**RE: 100 EDINBURGH ROAD, CASTLECRAIG
DRP No. 1 MONDAY 1st DECEMBER 2025
DESIGN ADVICE LETTER**

As you may recall, the first Design Review Panel (DRP) meeting was held in relation to a HDA SSDA at the abovementioned site on 1 December 2025. This correspondence represents the Design Review Panel's Design Advice Letter following the DRP of 1 December 2025.

01 Western Tower Rooftop Communal Open Space  
107 1:100

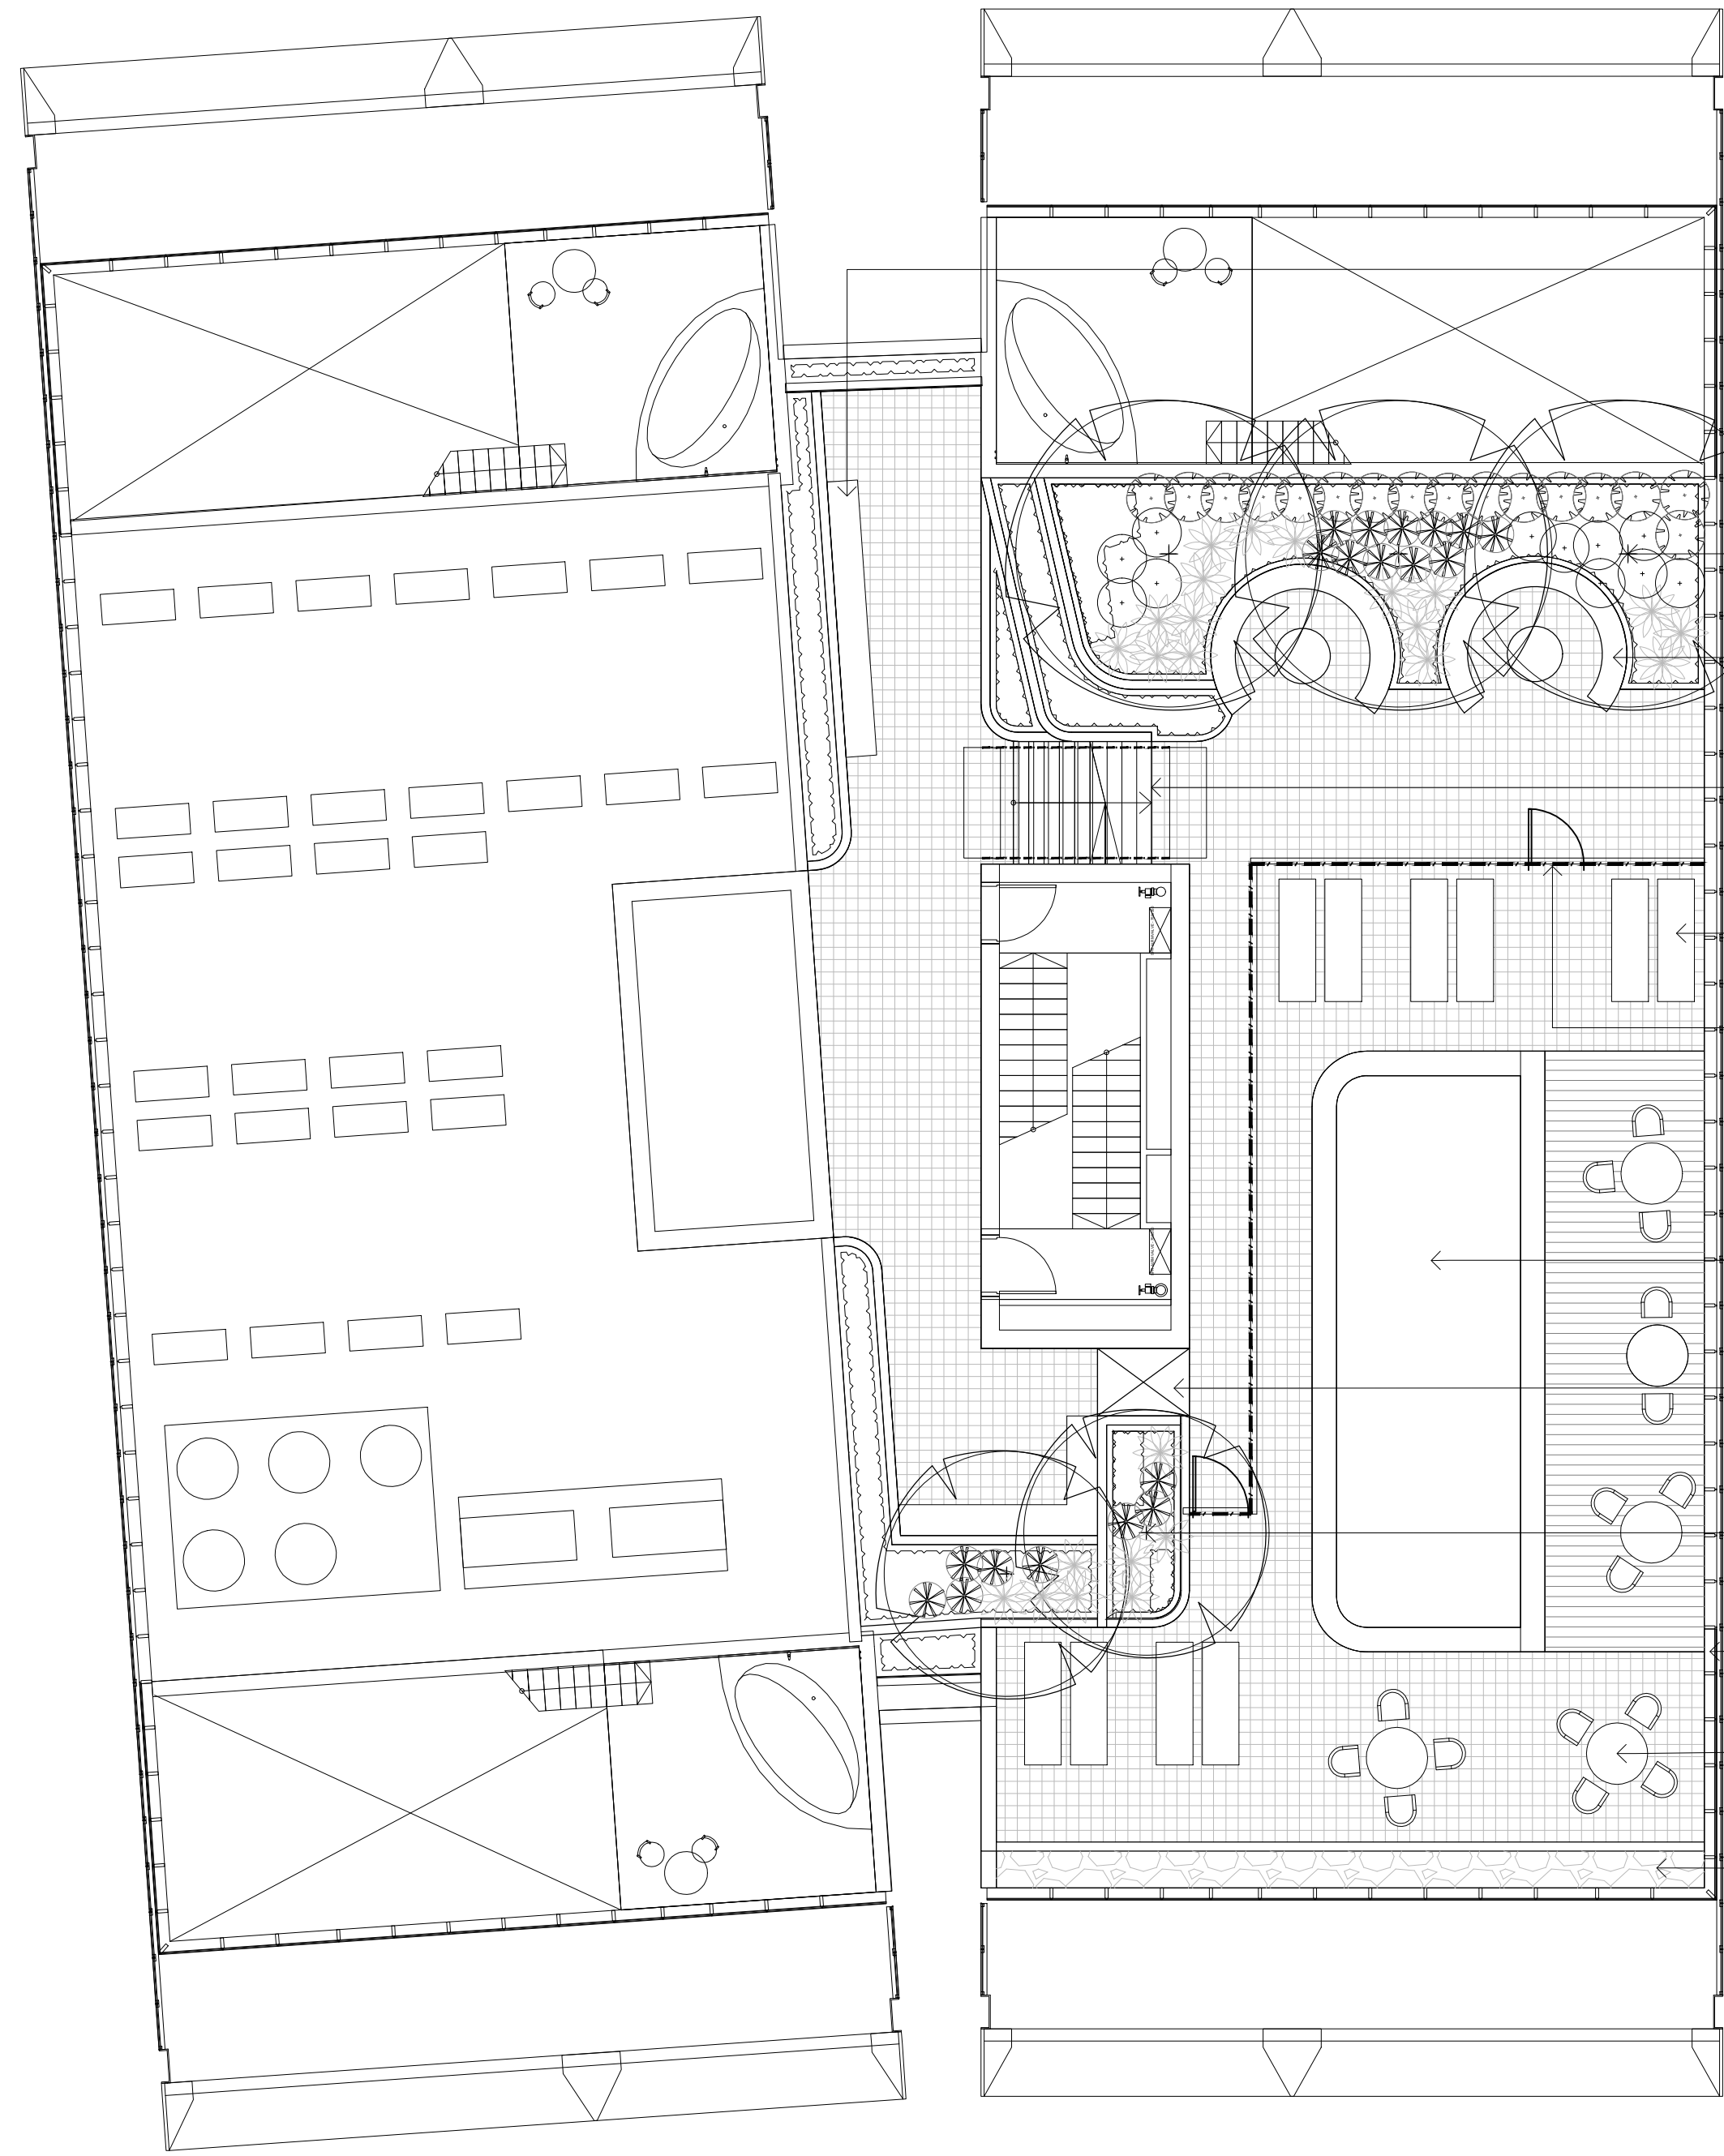
- Communal open space needs further consideration.
- Tree preservation.
- Community consultation - the Panel was advised that there is no requirement for another round of community engagement, however this should be confirmed with HDA/GANSW.

- Provide detailed wind analysis and strategies for ensuring wind comfort in the public domain, communal and private open spaces.
- Provide detail and evidence of communal open space provision.
